Cameron Sargent
Team Leader
Key Sites Assessment
Department of Planning & Environment
GPO Box 39
Sydney NSW 2001

**Development Application for Building C1, Barangaroo South (SSD 8529)
Notice of exhibition**

Objective Reference CD17/12428

Figure 9 Approved intersection layout – Hickson Road / Napoleon Street

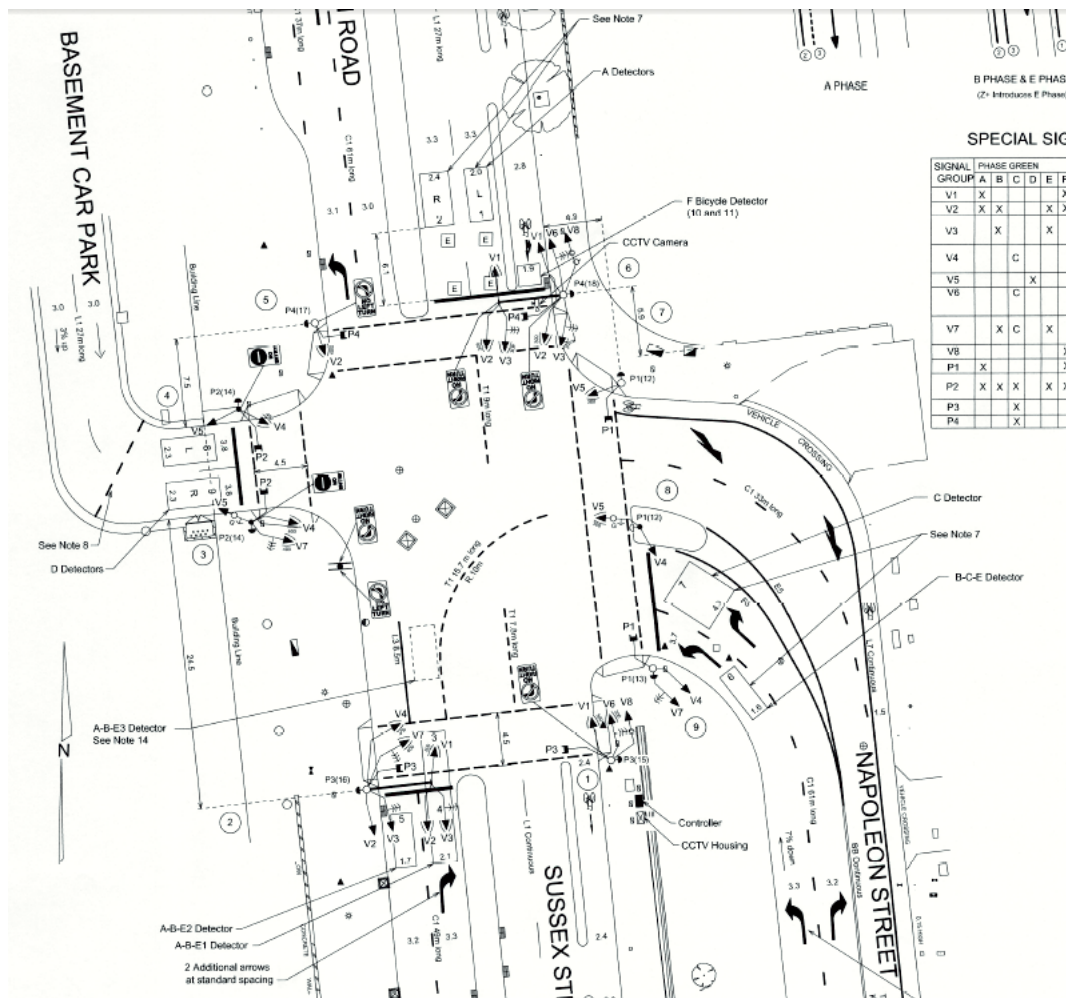
Comment

The Transport Assessment states the following:

- The layout of the Hickson Rd/ Napoleon St intersection has been approved and has been adopted for the subject development; and
- The detailed design of the Hickson Rd/ Watermans Quay intersection, including the phasing and lane arrangements, will take place closer to the construction date and be subject to consultation with the Road Authority and Roads and Maritime Services.

It is requested that the applicant undertakes the detailed design of the intersections, in consultation with the Sydney Coordination Office within TfNSW and Roads and Maritime Services, to accommodate a bus stop on the Hickson Road frontage of the site and bus operation along Hickson Road.

Figure 14 Commercial Building C1 end of trip facilities room

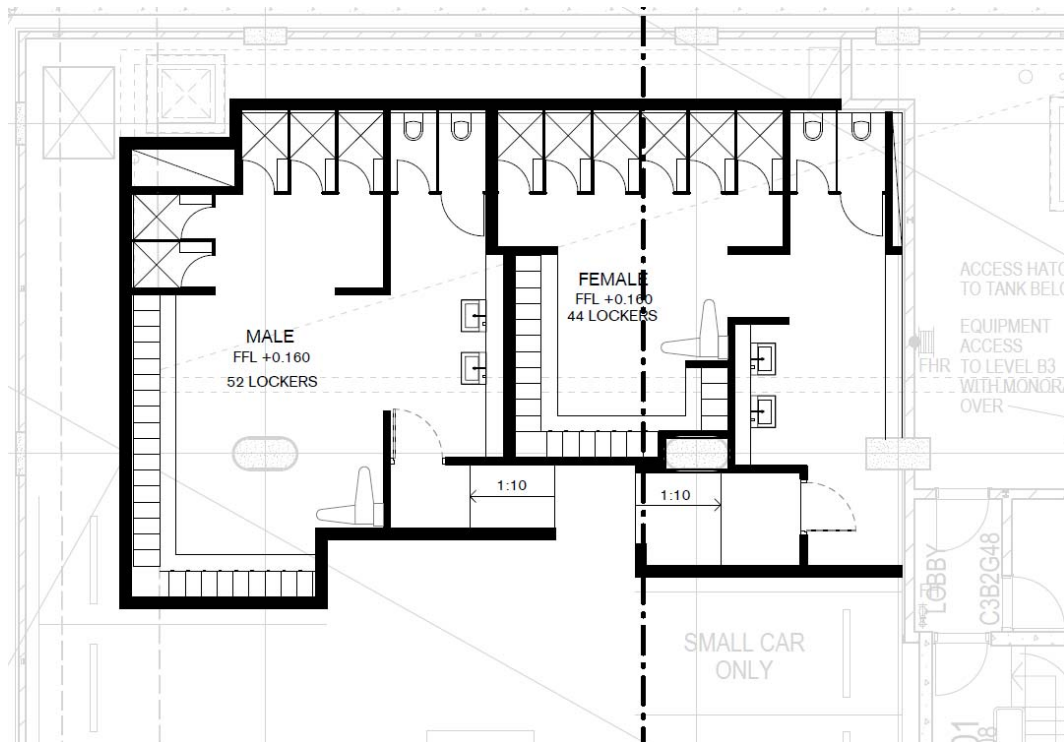
The Transport Assessment states that a total of 96 lockers and 35 bicycle parking spaces are proposed as part of the development. This quantum of bicycle parking is approximately 5% of the commercial population of Commercial Building C1. This rate is consistent with that recommended by the Green Building Council of Australia in their Green Star requirements.

- Provides bicycle parking and end of trip facilities for staff and visitors in accordance with City of Sydney Council development control plans, standards and guideline documents;
- Locates bicycle facilities in secure, convenient, accessible areas close to the main entries incorporating adequate lighting and passive surveillance and in accordance with Austroads guidelines; and
- Develops wayfinding strategies and travel access guides to assist with increasing the mode share of walking and cycling, as recommended in the Transport Assessment.
